KITITAS COUNTY

MEMORANDUM

SUBJECT: Timber Ridge Lot 9 Short Plat SP-08-19

VICINITY MAP
N.T.S.

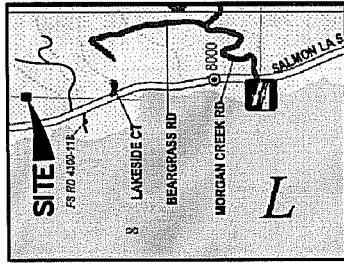
1. Vicinity Map Page 1: The vicinity map shall be corrected to accurately depict the location of the short plat.
2. Vicinity Map Page 2: The map appears to show that each lot was created in the “Night Skies” Plat. The lots in this subdivision were created by the Timber Ridge Plat. This shall either be corrected or clarified to prevent confusion.

NW 1/4 SEC. 9
1"=500'

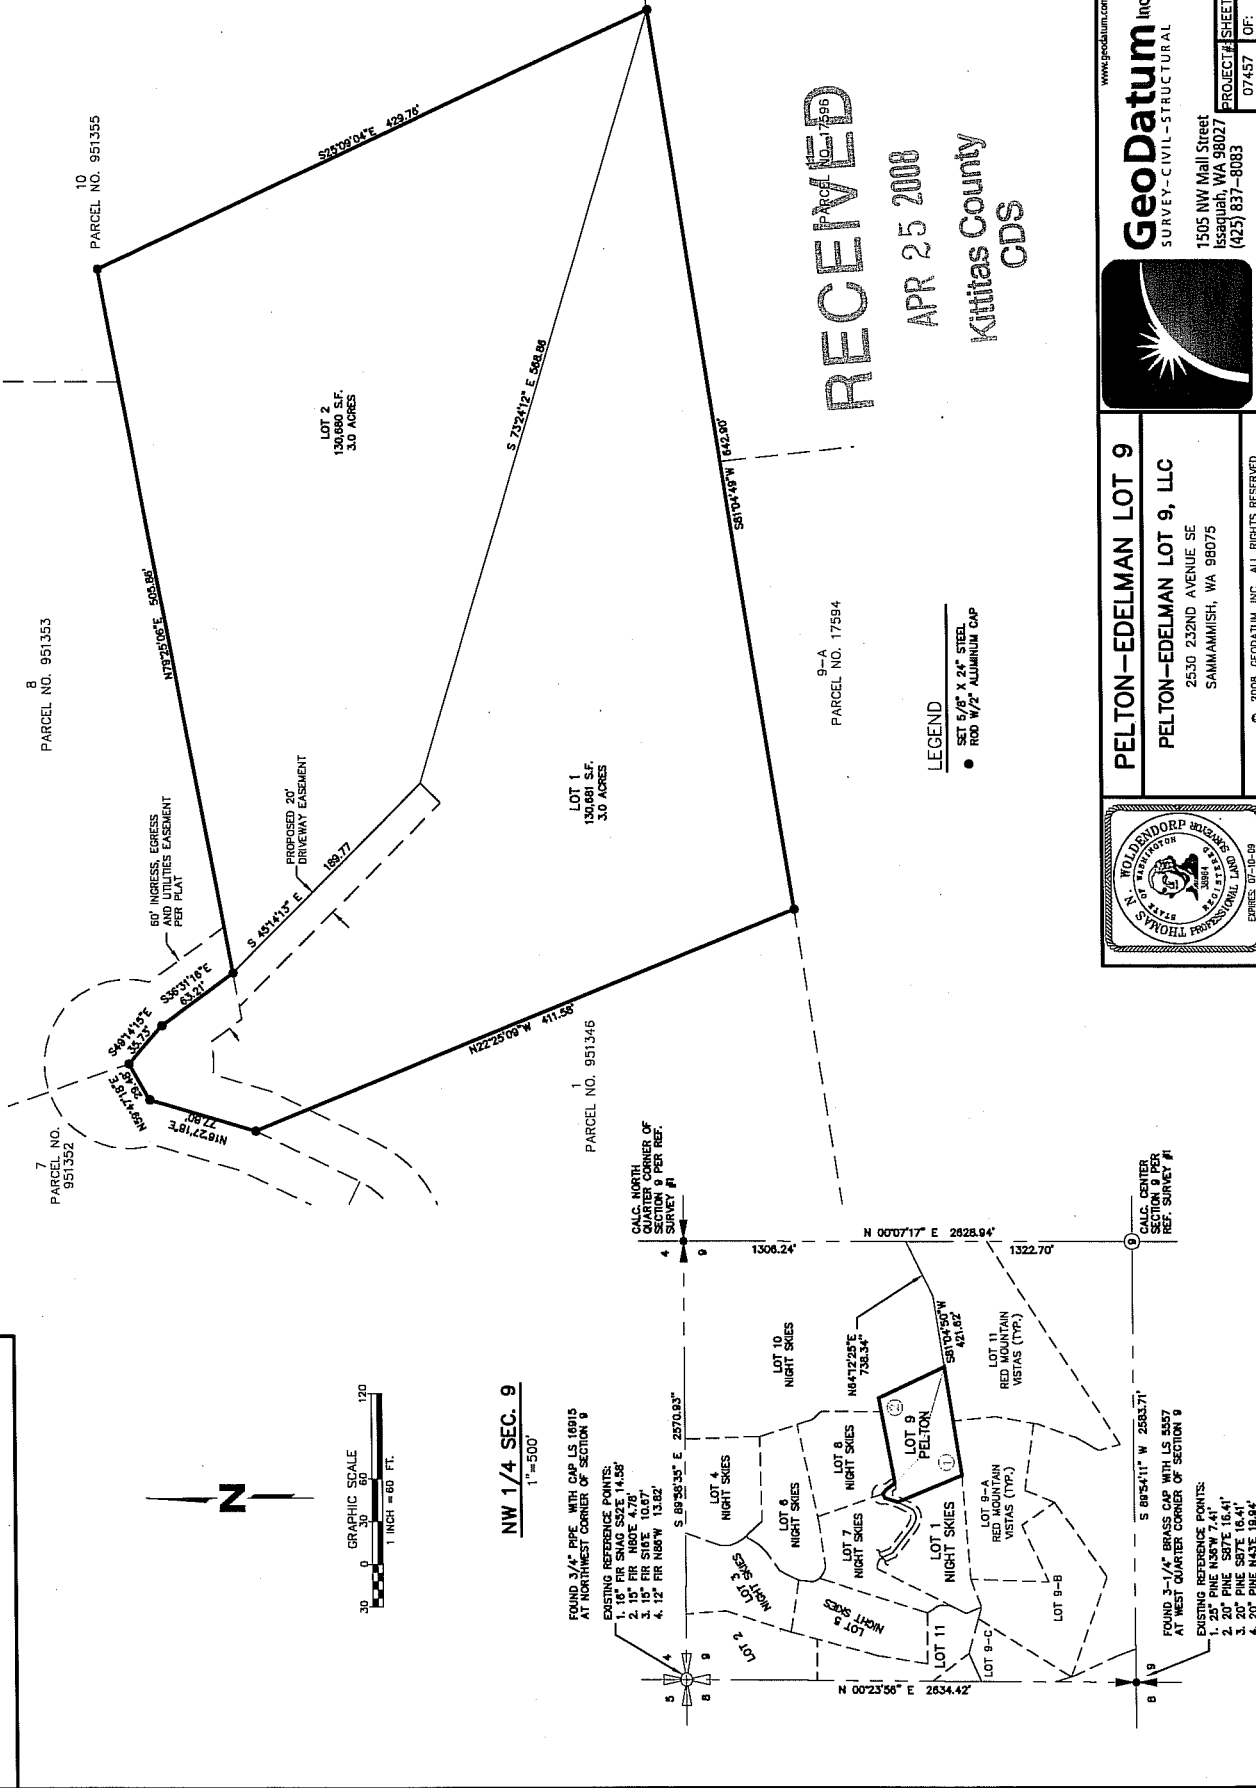
3. Easement AFN: The Auditor’s Filing Number for the access easement shall be shown on the plat.
4. Night Sky Drive: Night Sky Drive shall be labeled and shown from the plat to Salmon la Sac Road. This can be shown in the vicinity map if clearly illustrated.
